Online Comment

Application H02-0749-19
Location 2 West Bank West Bank Crowland PE6 0HP
Proposal Proposed three-bed detached dwelling

title
PROPOSED ELEVATIONS (2)

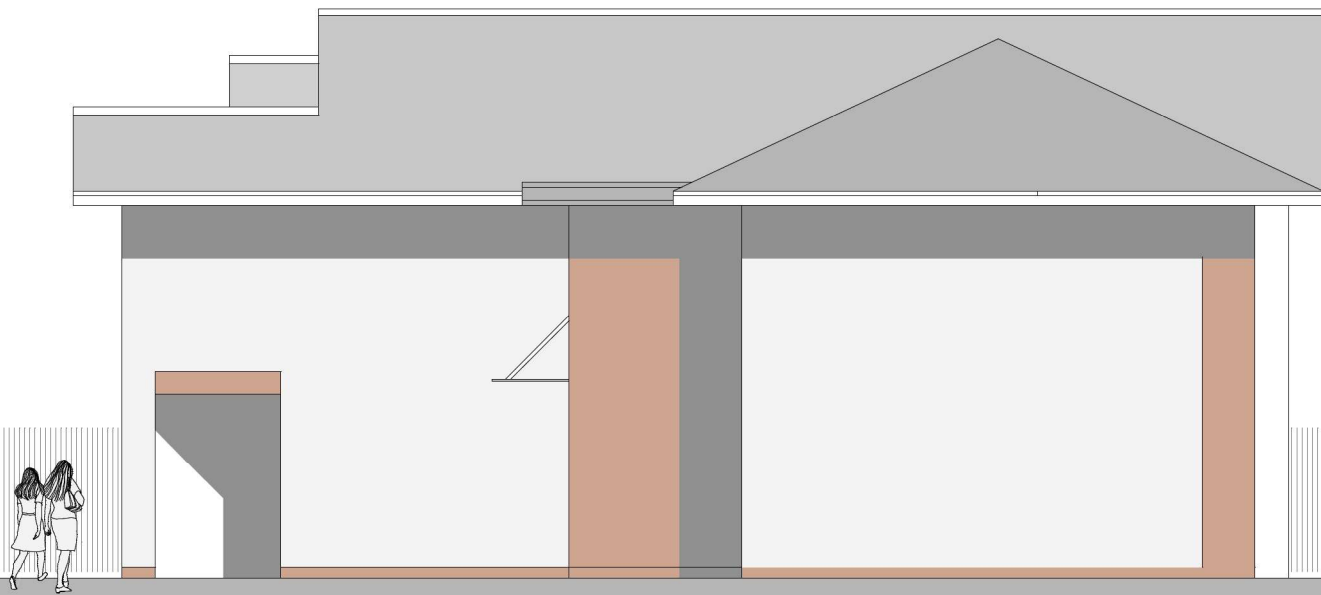
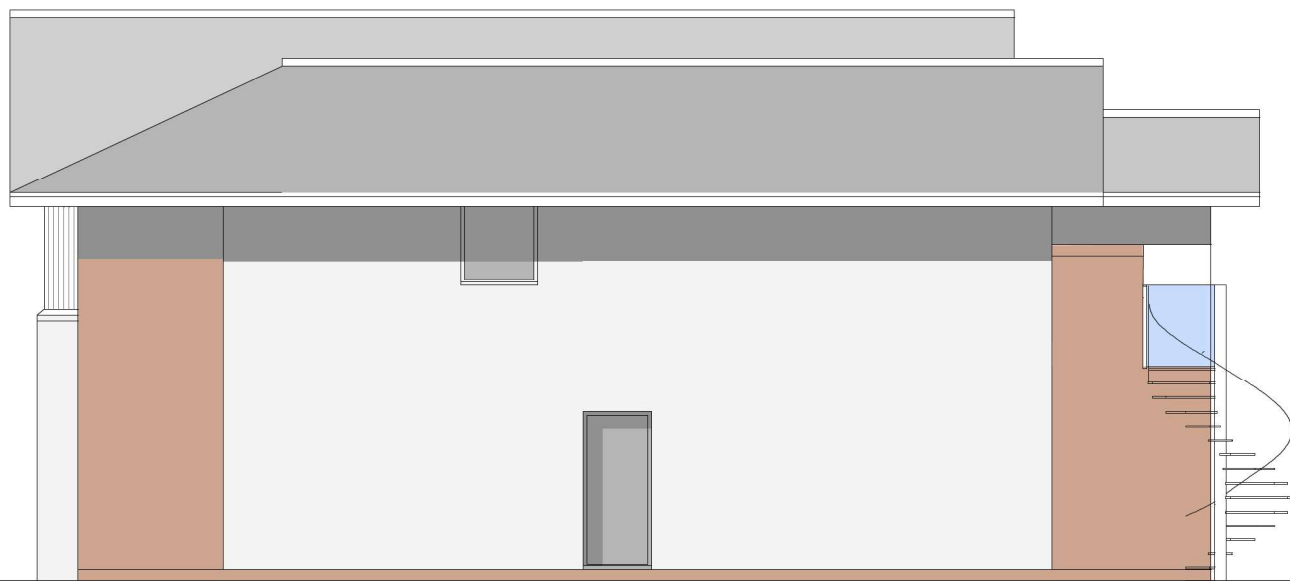
This office is concerned that these revised designs are less sympathetic to the surrounding Crowland Conservation Area than those previously submitted.

The increase in size of the present design, combined with the use of white render for the wider main elevation to West Bank would have a much greater impact on views across the Conservation Area and the Grade I Listed Abbey than the previous design.
